**WEST SUSSEX COUNTY COUNCIL
INFRASTRUCTURE CONSULTATION**

DATE: 17th August 2010

SUBJECT: LU/244/10 - Erection of 1 no. 2 bedroom semi-detached dwelling.

14, Highdown Drive, Littlehampton, West Sussex, BN17 6HJ

SITE PLAN 1:500

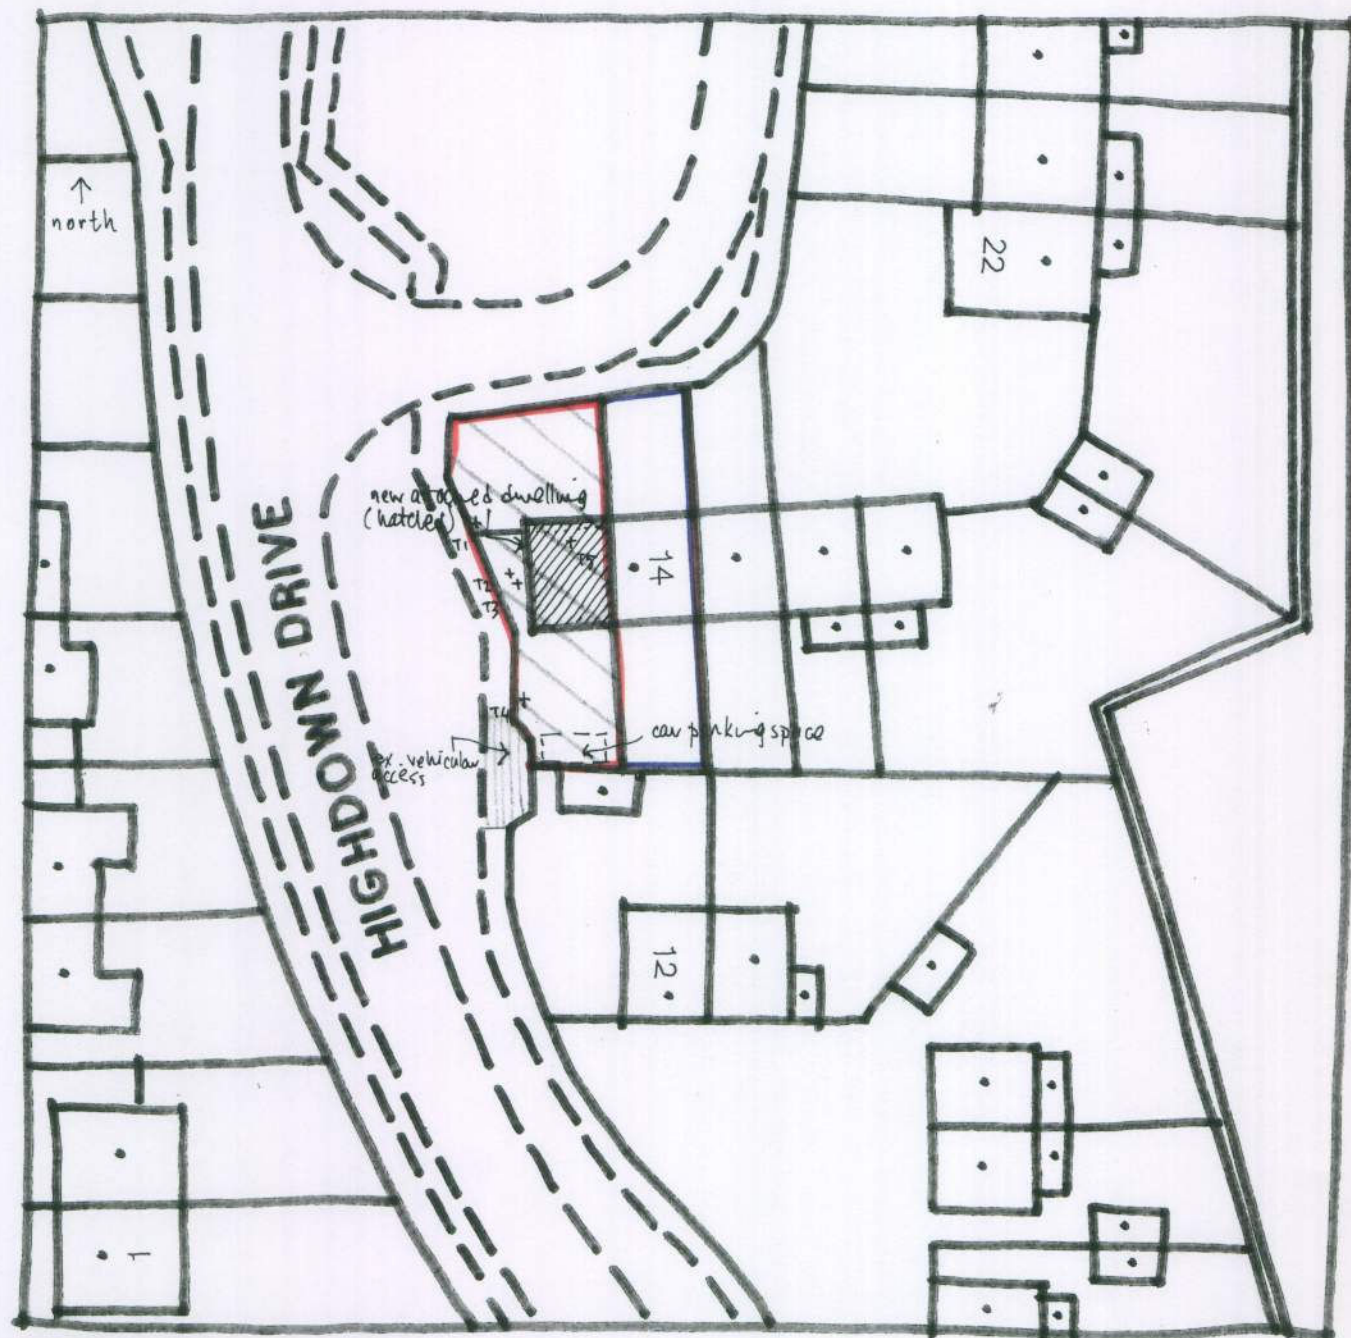
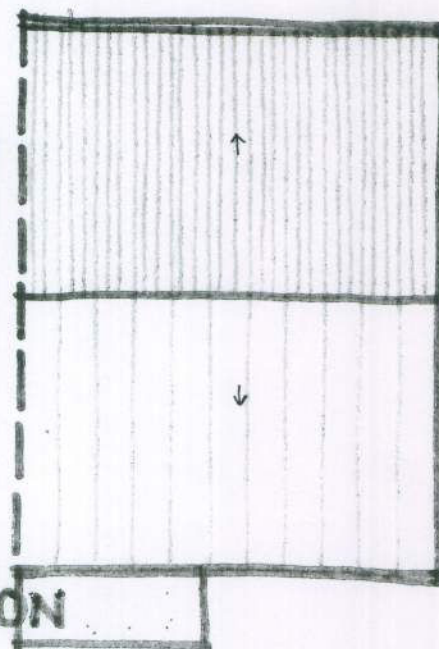
The proposal is for a single dwelling unit with access onto Highdown Drive via an existing access point. From an inspection of the plans alone, there is no apparent visibility issue at the point of access onto Highdown Drive. The most recently available verified accident records reveal there have been no personal injury accidents in the vicinity of the existing point of access, indicating a low risk of highway safety issues with this proposal.

It is recommended that any gates to be used as part of the access open into the property rather than out towards the highway.

If the LPA are minded to approve this application, a condition securing cycle parking should be included.
